STORMWATER AUDIT (STAGE 1)

JBA Project Code 2022s0368
 Contract SHD Priorsland, Cherrywood SDZ, Co. Dublin
 Client 1 Carrickmines Land Ltd.
 Date 31st March 2022
 Author Chris Wason
 Subject **Stormwater Audit - Stage 1 Report**

1 Proposed Residential and Retail Development, Priorsland, Cherrywood, Co. Dublin.

Job: PRIORSLAND CHERRYWOOD SHD
 Title: TYPICAL ATTENUATION TNAK DETAILS - PERMANENT PROPOSAL

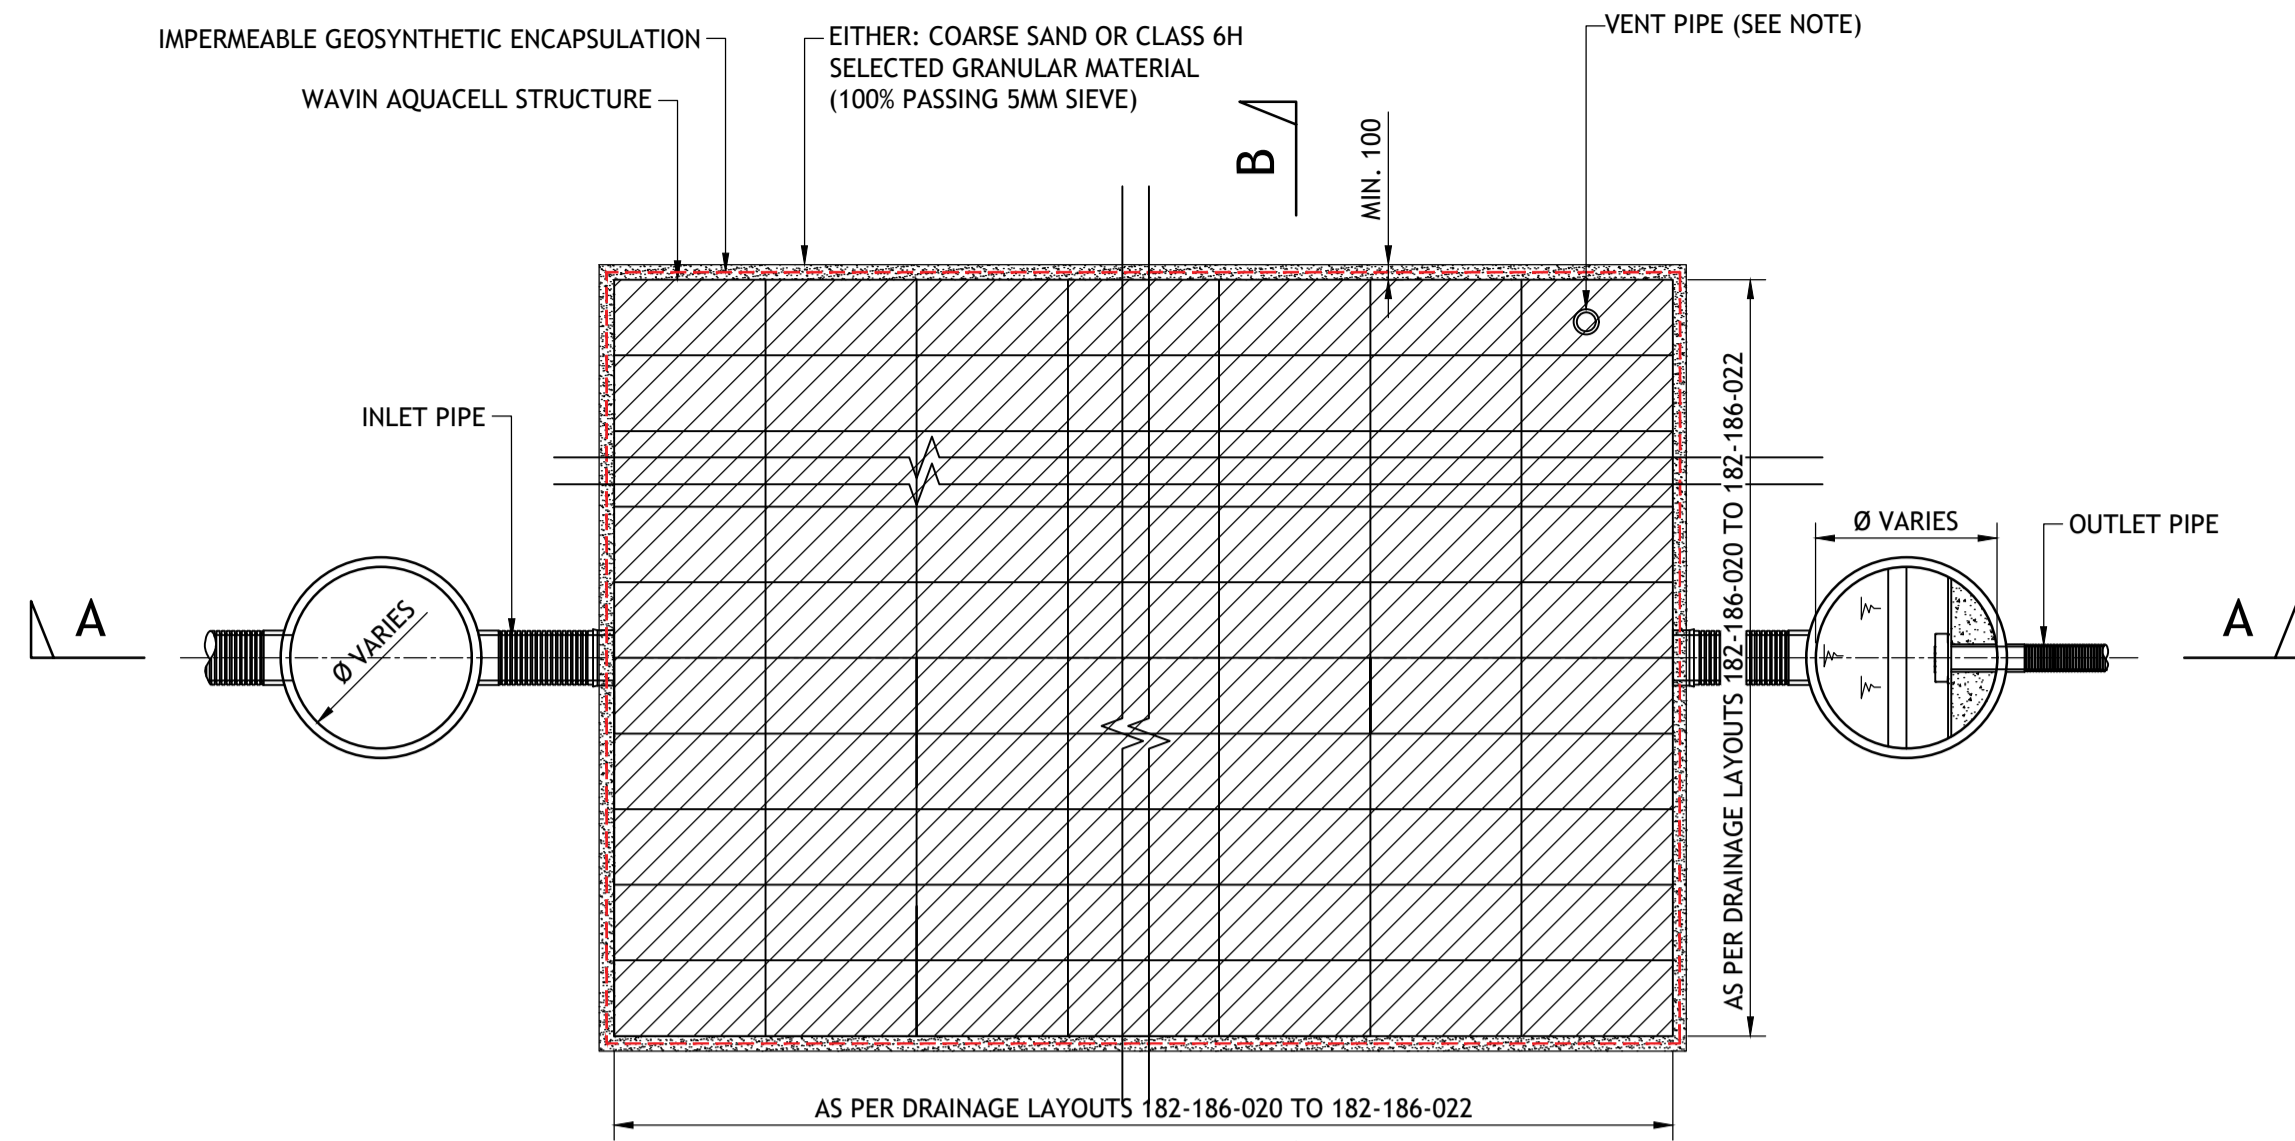
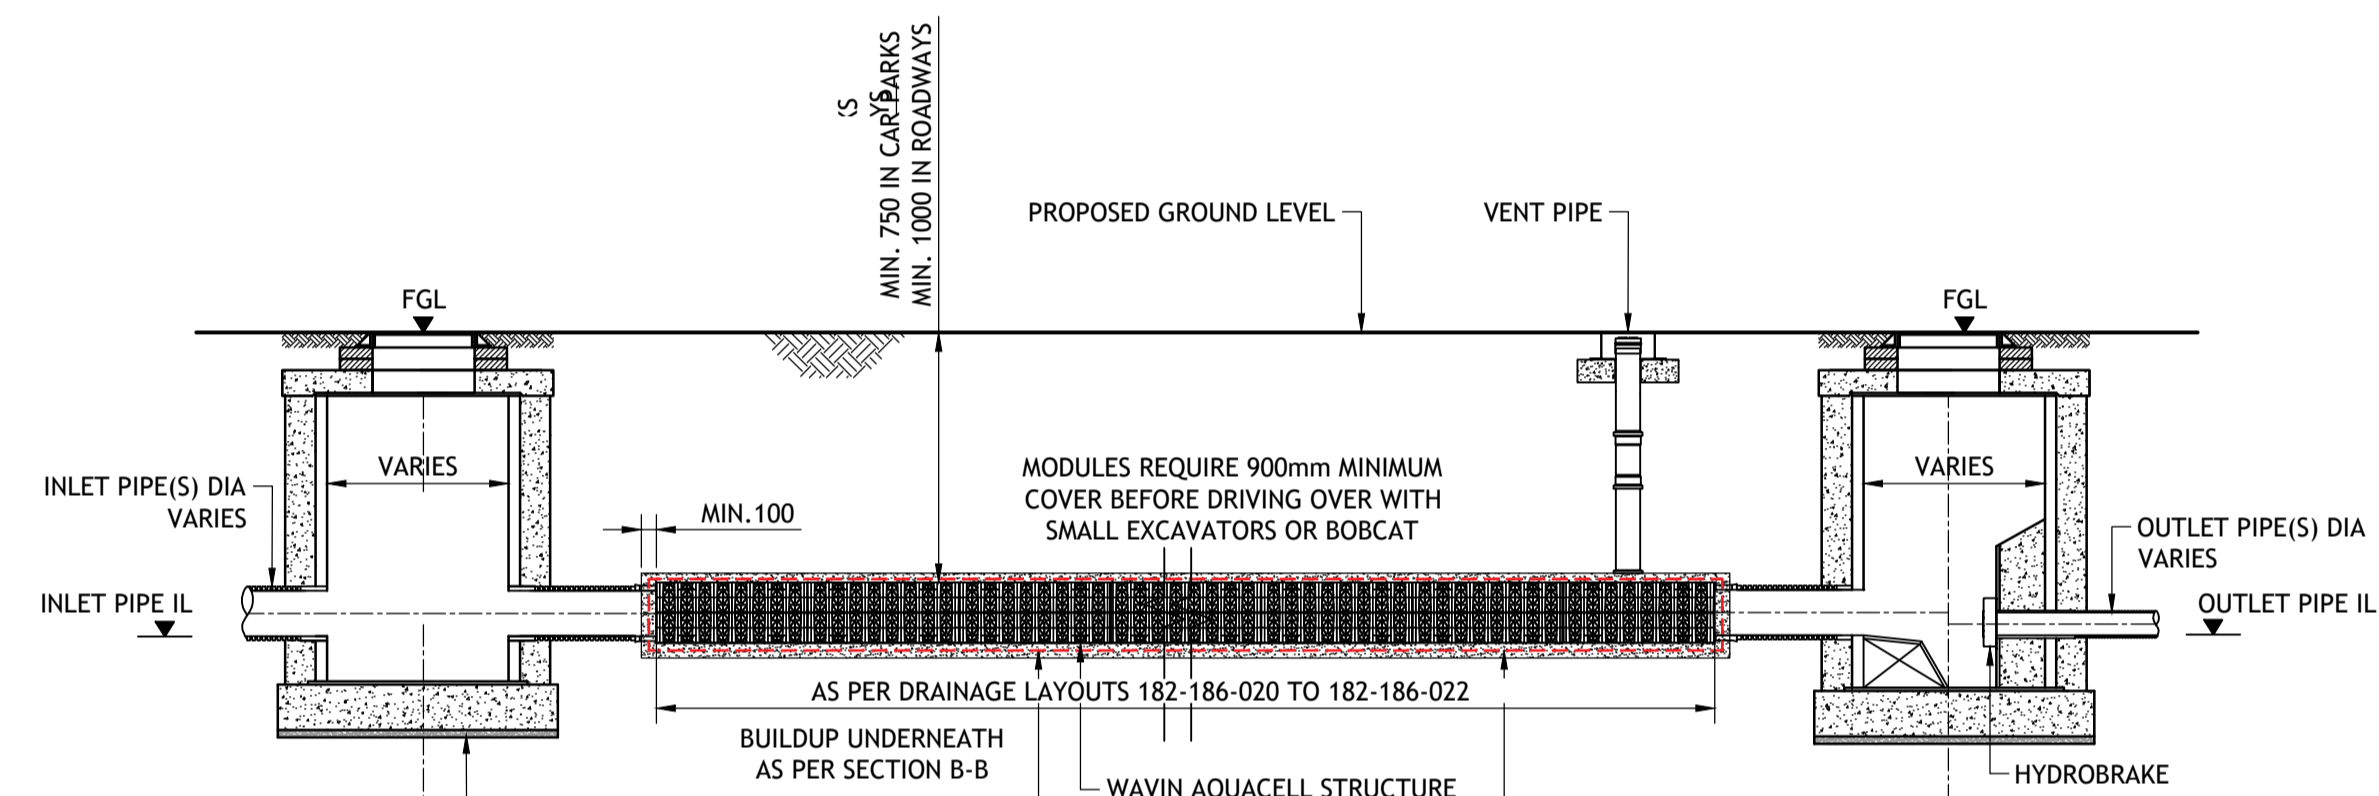
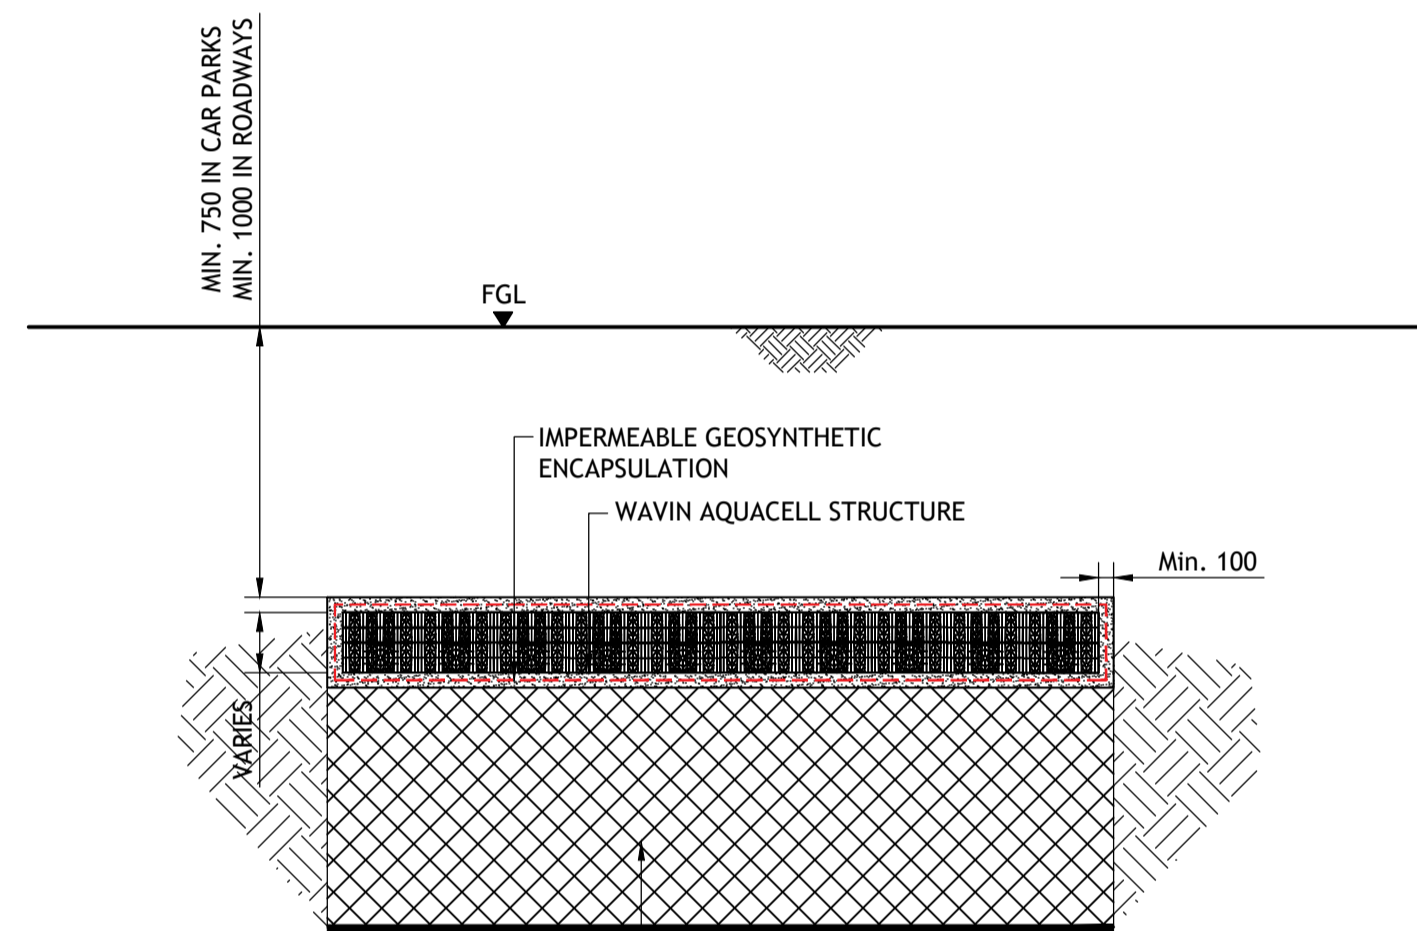
Volume Storage	A number of storage units with pump or hydrobrake flow controls are located throughout the development. No details are provided but it is assumed that those under basements on drgs 011,012,013 are concrete tanks which are not preferred. Punch in their Feedback Form response have confirmed and justified the use of RC tanks.
Treatment Volume / Water Quality Improvement	Interception storage of 5mm is currently proposed by way of green roofs, permeable paving, swales, water butts and tree root systems and interception trenches comprising 30% porosity stone. A suitable treatment train is also in place. Table 5 in the report lists the methods of interception proposed and appears to be in compliance with Table 24.6 of CIRIA 753. The total area noted is 5.027ha. which is 100% of the impermeable area but in actual fact the GSDSDS allows a reduction to 80% for interception so that provided is conservative. However, it is not clear on drg 011, 012, 013 how car park drainage is to be intercepted. Are these areas to be permeable paving? The Suds Management train diagram in the report indicated that they will discharge to engineered swales but this is not as shown on drawings if they discharge to a concrete tank and then to the regional detention pond. Car park runoff should be intercepted at source where possible. Punch have provided some additional typical detail in their Feedback Form response. Traditional gullies etc are used as collection systems as required in the CPS but these are only in case of failure of permeable/porous paving which should allow runoff to percolate and then be directed to the collection system as required. Suitable stone build up should allow for this. Details should be provided at detailed design stage. The CPS states that <i>runoff from all sites must pass through at least one level of treatment.... prior to the final level of treatment in the public realm areas.</i> Generally, this has required that 5mm is intercepted in the private development and 10mm in the public realm areas, in this case, in the detention pond proposed. However, there are no calculations or details to show how the detention pond sizing has been arrived at. Typical details of the ponds are provided. Punch should provide details of the detention pond proposal and clarity if these are to be become part of the public realm.

Item No.	JBA Review Comment	Comment/Clarification Request/Suggested Mitigation	Response from Client/Client Representative	Acceptable / Not Acceptable
	25/03/2022	25/03/2022		30/03/2022
	General			
1	It is assumed that basement tanks are to be RC units which are not preferred	Punch to clarify and if RC units justify their use.	<p>The design of the proposed attenuation tanks sited below basements/buildings have been considered following <i>Chapter 21 Attenuation Storage Tanks</i> of the <i>CIRIA SuDS Manual 2015</i>.</p> <p>The attenuation tanks below basements/buildings are proposed as RC tanks for the following reasons:</p> <p>1) RC tanks with waterproofing solutions will result in waterproof tanks, derisking water ingress into the storm drainage system from ground water. It is more straightforward to address waterproofing issues with an RC tank than a modular tank underneath a building should any issues during construction arise. Where tanks are located in open ground, excavations are possible and therefore modular tanks are proposed in those instances.</p> <p>2) RC tanks reduce risk of larger maintenance issues in 5+ years which is a significant consideration where the tanks are located below basements/buildings. It will not be feasible or safe to dig to the tanks once the buildings overhead are constructed.</p> <p>3) RC tanks reduce risk of damage to the tanks during construction, which is a significant consideration as temporary works and permanent buildings will be constructed above the tanks and the tanks will be overrun by construction plant.</p>	Accepted
